FW: SUB19-002 (SEP19-005/Requirement For No Onsite Open Space/Lack of Tree Regulation)

From: Dan Thompson <danielphompson@hotmail.com>
Sent: Friday, December 22, 2023 2:58 PM
To: jeff.thomas@mercercisland.gov <jeff.thomas@mercercisland.gov>
Cc: jessi.bon@mercergov.org <jessi.bon@mercergov.org>; council@mercergov.org <council@mercergov.org>
Subject: SUB19-002 (SEP19-005/Requirement For No Onsite Open Space/Lack of Tree Regulation

This is the application for a long plat on the old Boys and Girls Property the MI school dist. donated to the BGC in 1984 for recreation. I have a post on ND addressing this. https://nextdoor.com/p/mSBjhfBt7hsB?utm_source=share&extras=NDE0NTk4OQ%3D%3D&utm_campaign=1703284690389

CITY OF MERCER ISLAND
PLAT NO. _____

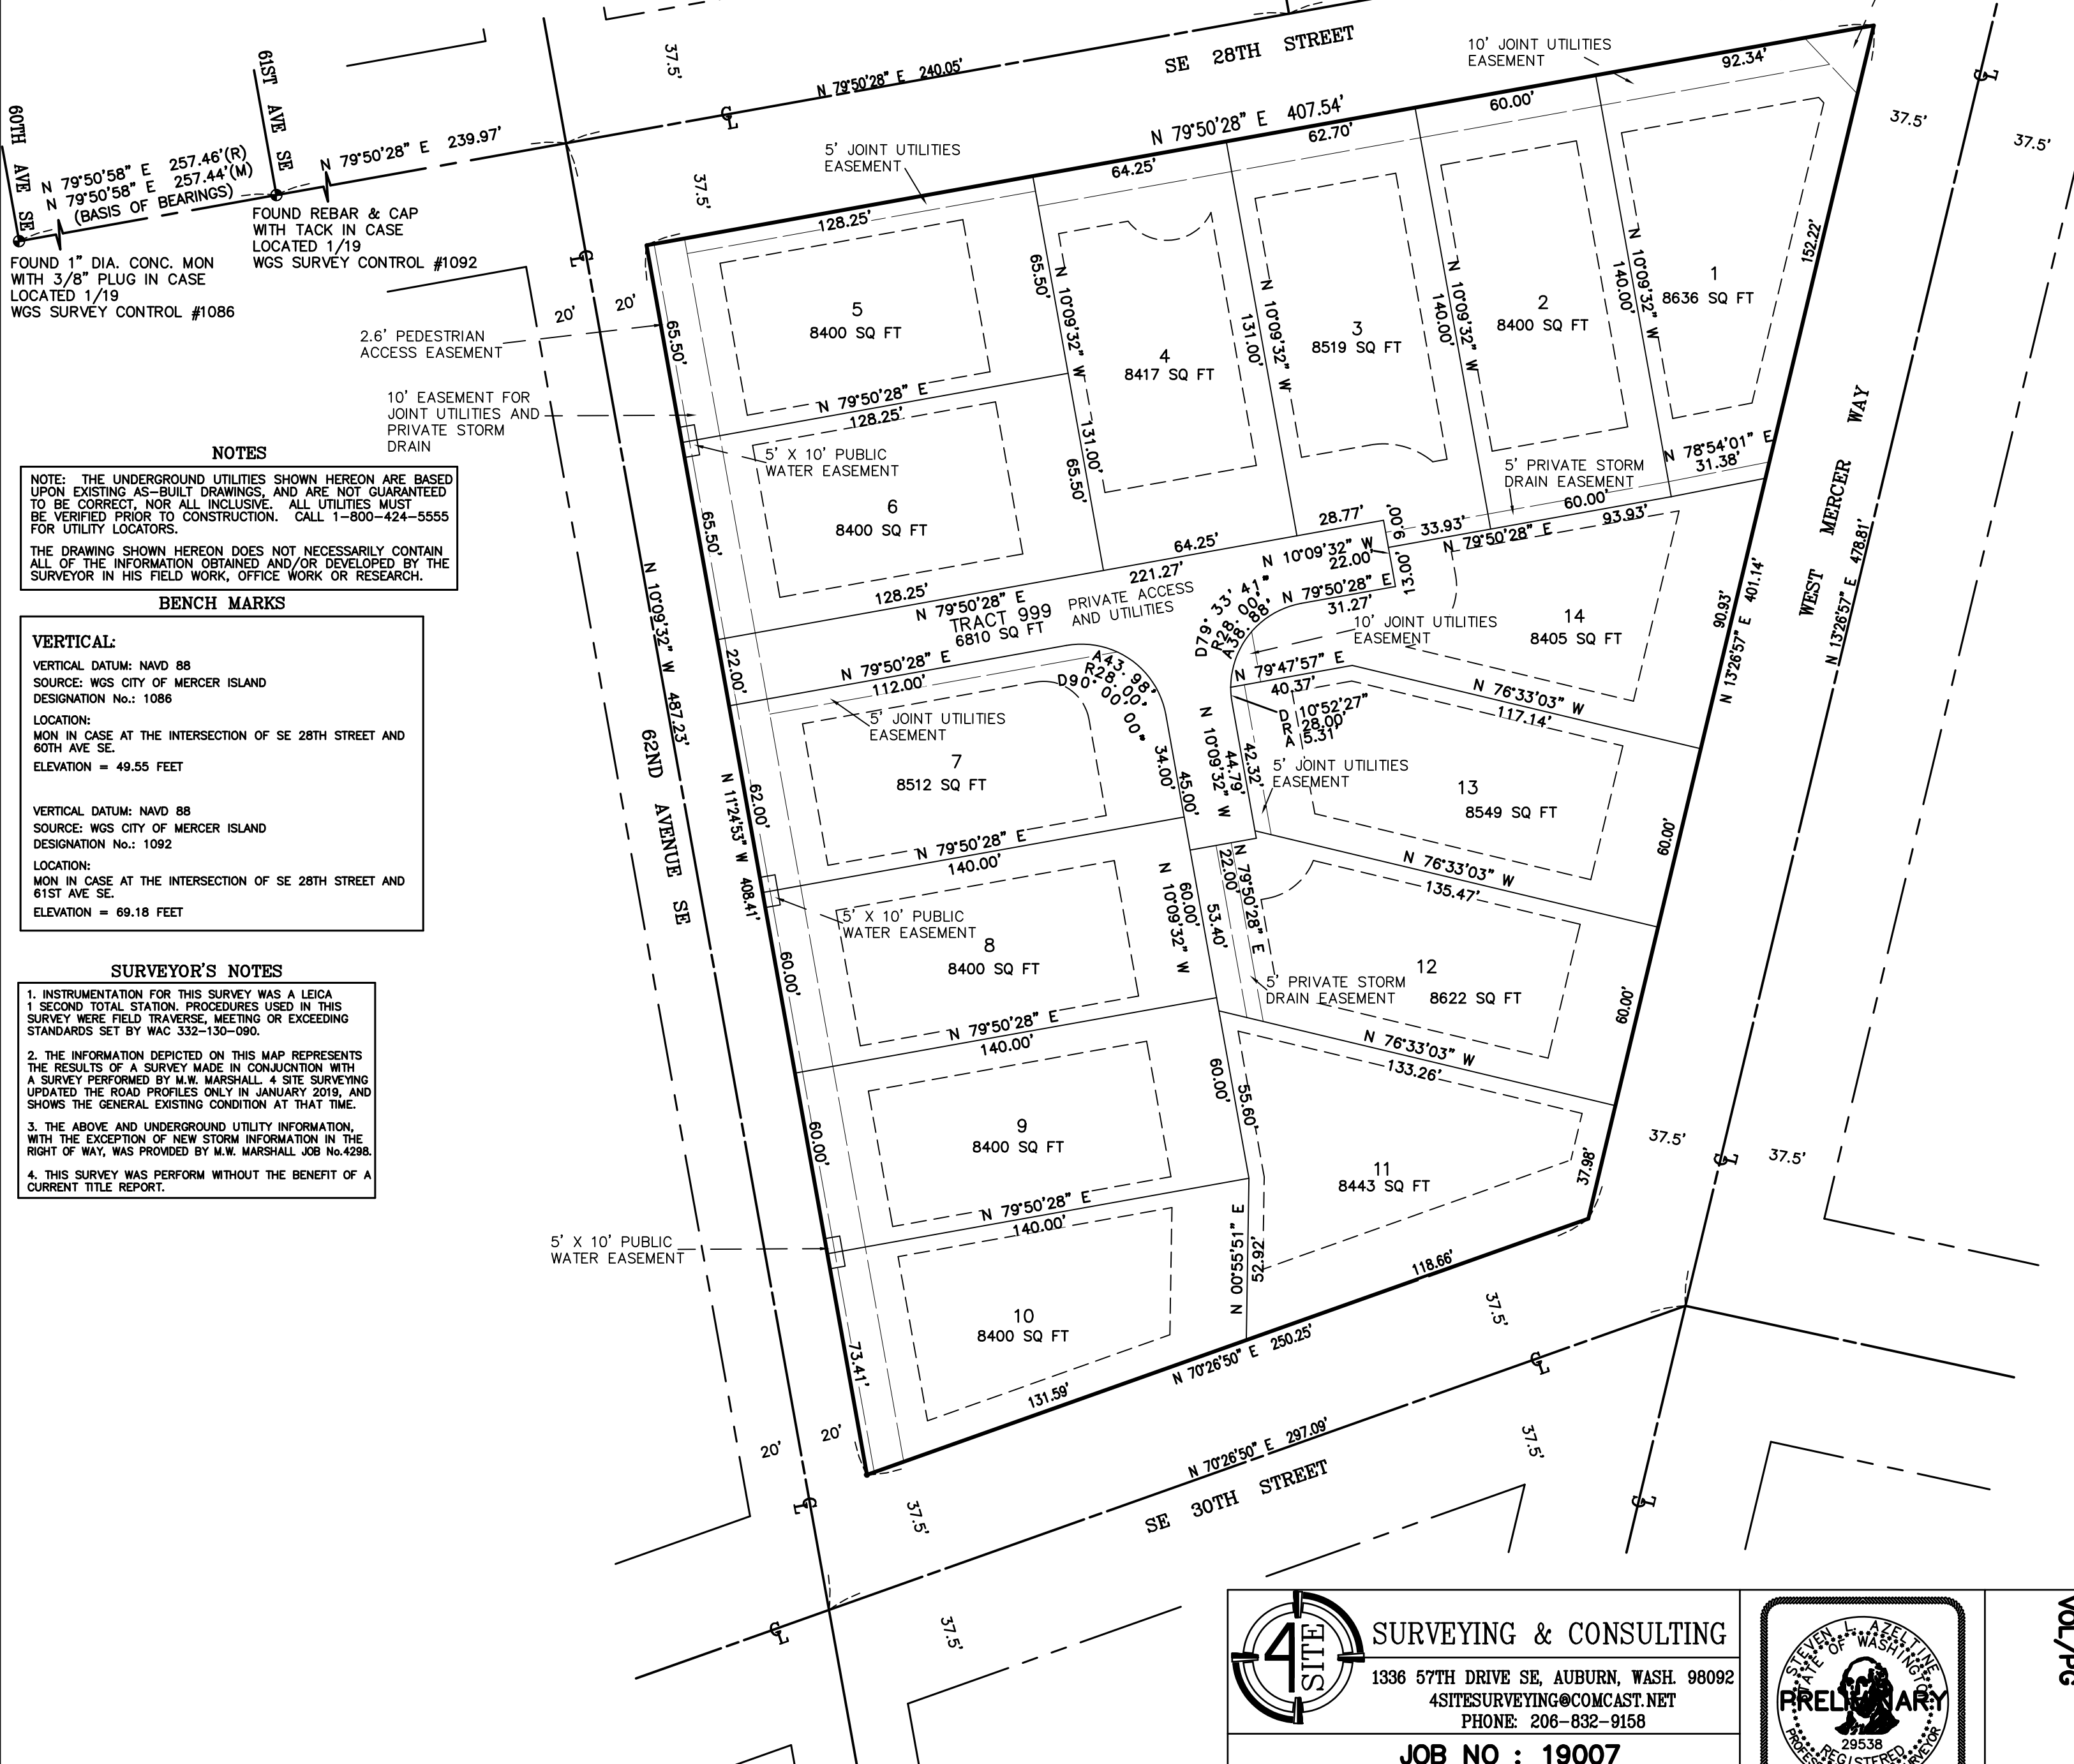
Here is a site map for the proposed 14 plat long division. [12. pin2174502425-supp-platmap.pdf \(mercergov.org\)](#). The only "open space easement" listed on the map is the tiny triangle in the upper right-hand corner.
